2005-0236
Application I. D. Number
10/12/2005
Application Date
Ruby Lane #14
Project Name/Description

RE: Application for Single Family Residences, Ruby Lane lots #13 and lot #14

Upon review of the site plans, the City's Planning Division has the following comments:

LOT 14 GRADING & EROSION
 CONTROL PLAN

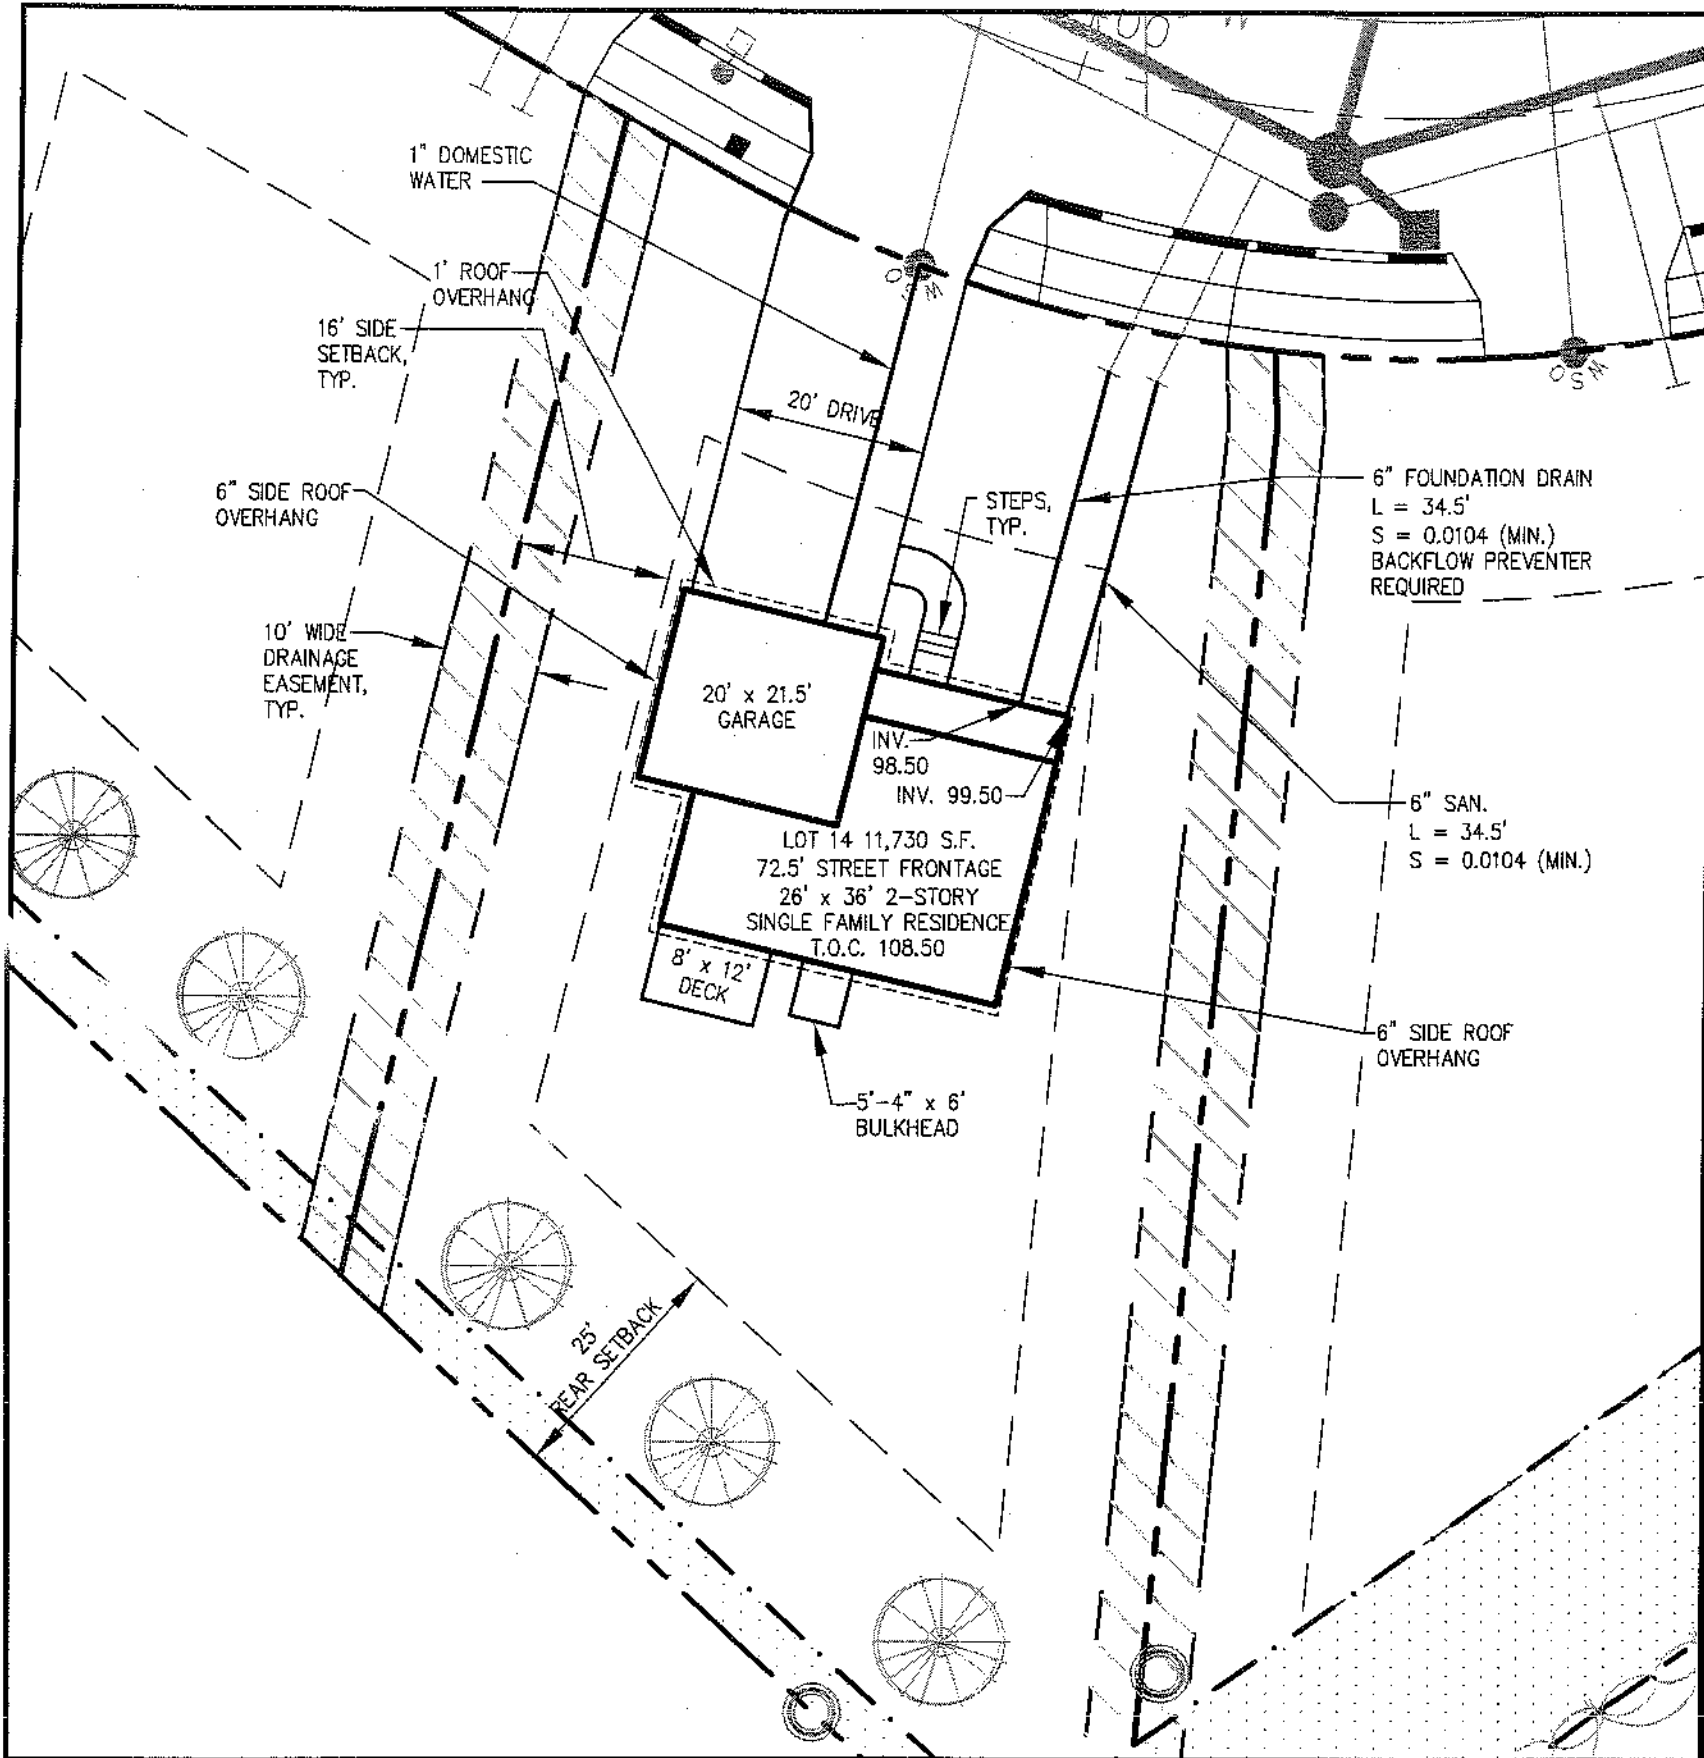
1. Street tree shown over the utilities needs to be moved.
2. The topography and spot grades indicate that the rear yard will be pitched towards the building. Please correct.
3. Please label the no-cut/undisturb zone along the rear property line.
4. The curb cut on your plan does not match the curb cut location on the approved subdivision plans. Please clarify.

1. Please add two street trees to your plan.
2. Same items listed above (2., 3., and 4.).
